**KIRKLEES METROPOLITAN COUNCIL
INVESTMENT & REGENERATION SERVICE**

Reference No: 2018/62/90765/W

Site Address: 158, Laund Road, Salendine Nook, Huddersfield, HD3
3TY

Description: Erection of single and two storey rear extension

Dwg No. - 8242/03a

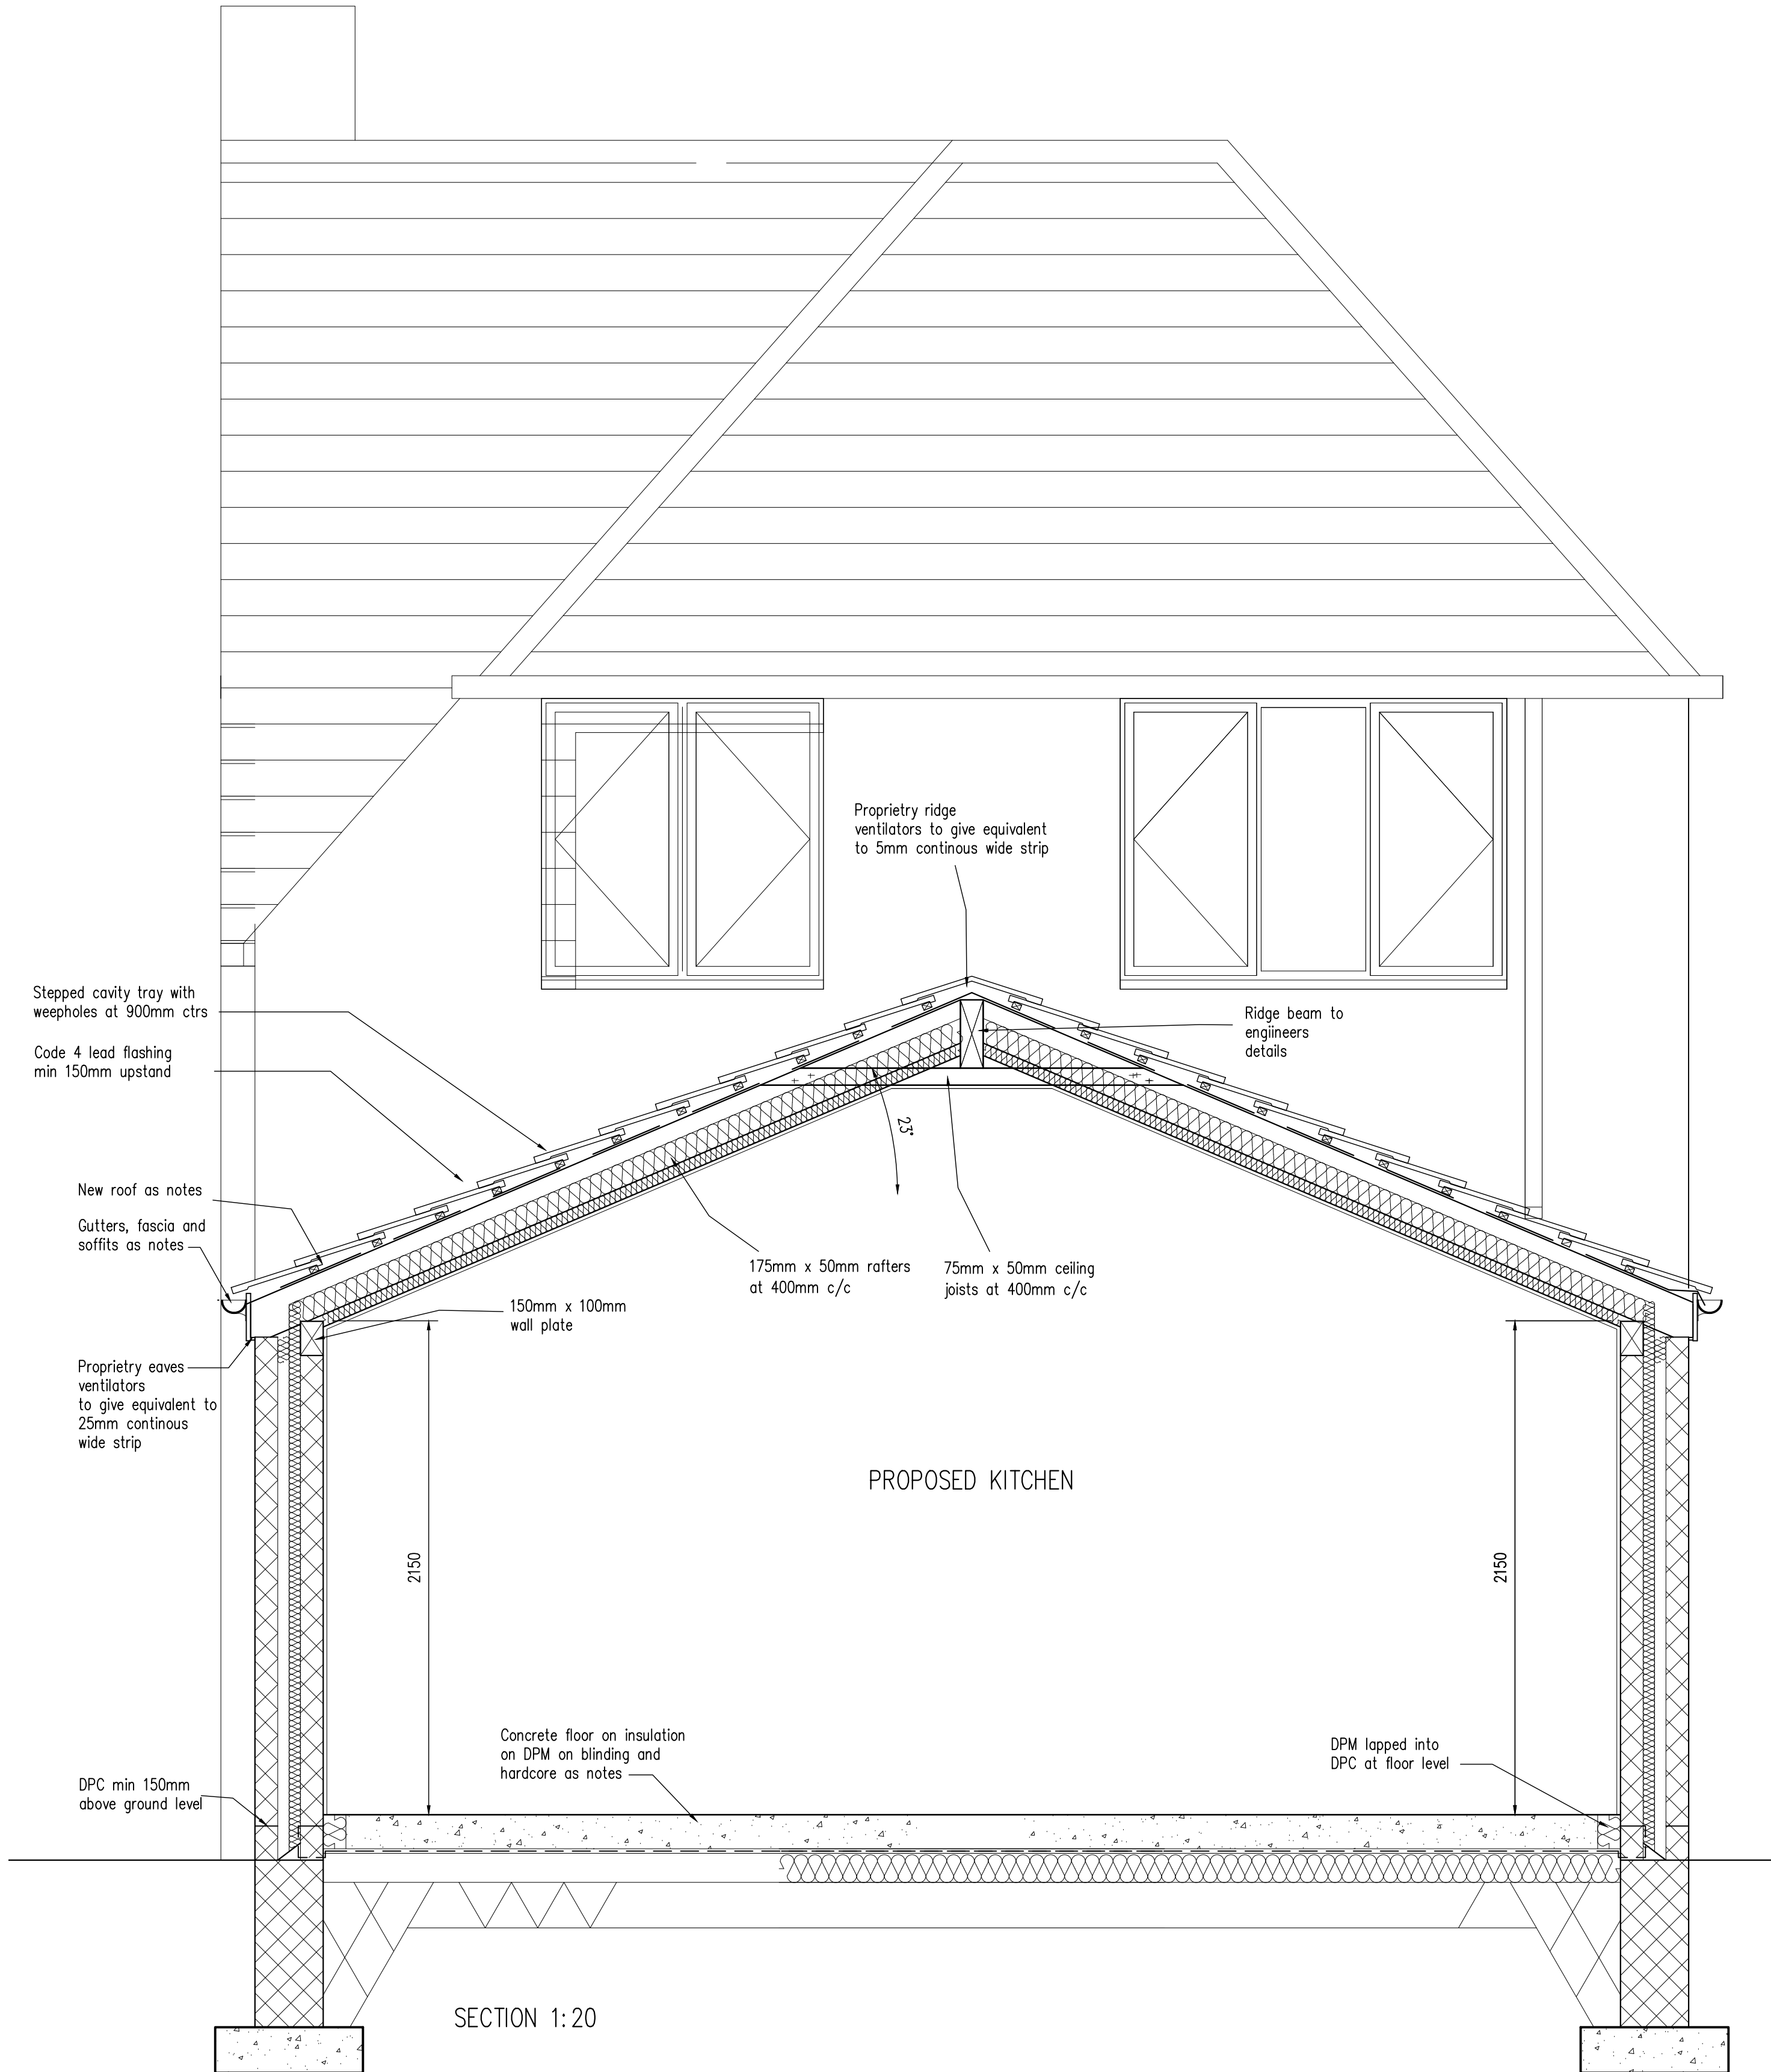
The extension would span the full width of the rear elevation lying flush with the existing side elevation being set in from the boundary with No. 156 by 0.15 metres. The extension would project 6 metres from the rear elevation at ground floor level and 3 metres at first floor level.

The roof at two storey height would follow the eaves line from the existing gable end of the property and would include a hipped gable with flat roof top, at the same height as the existing flat rooftop. The roof would then return to meet the adjoining property at a higher level than the existing and adjoining property by 1.25 metres. It is proposed that the higher eaves section would be set in from the adjoining property by 1 metre.

The single storey extension would have a pitched roof which would have an eaves height of 2.5 metres rising to 3.8 metres to the ridge.

The difference between this submission and the previously refused submission is that the eaves of the two storey element have been set in from the shared boundary by 1 metre.

The proposal has been amended since the recently refused application by setting the eaves of the two storey element in from the shared boundary by 1 metre. This results in a design that visually appears awkward and unsymmetrical which would remain visually intrusive when viewed from the rear.

The proposed extension would be located 0.15 metres from the boundary with the adjoining property, No. 156. Again, no windows are proposed (other than a roof light) facing this property and therefore, there are minimal concerns regarding overlooking.

The extension would be located to the north-west of the attached property it is not considered that there would be a loss of direct sunlight to the neighbouring dwelling. Whilst it is noted that the roof form has been set in by 1 metre from the previously refused application, the scale and mass of the proposal is still considered to be overbearing to the attached property, particular with regard to the proximity of the extension to neighbouring windows at ground floor and dormer level and to the private amenity space. The proposal would therefore fail to accord with Policy D2(v) of the UDP, Policy PLP24(b) of the Publication Draft Local Plan and a core planning principle of the NPPF which is to retain a good standard of amenity for existing occupier of buildings and land.

The proposed two storey rear extension by reason of its height, depth and mass would change the overall form, design and character of the host property and the pair of semi-detached properties of which it is a part to an inordinate and unacceptable degree and would be detrimental to the visual amenity of both the application dwelling and the adjoining dwelling.

Furthermore, the scale and mass of the proposal would be detrimental to the occupiers of 156 Laund Road by reason of overbearing. To permit such a development would be contrary to Policies D2 (v, vi, vii), BE2(i), BE13(iii, iv) and BE14 of the Kirklees Unitary Development Plan, Policy PLP24(b and c) of the Kirklees Publication Draft Local Plan and the core planning principles and policies in Chapter 7 of the National Planning Policy Framework.
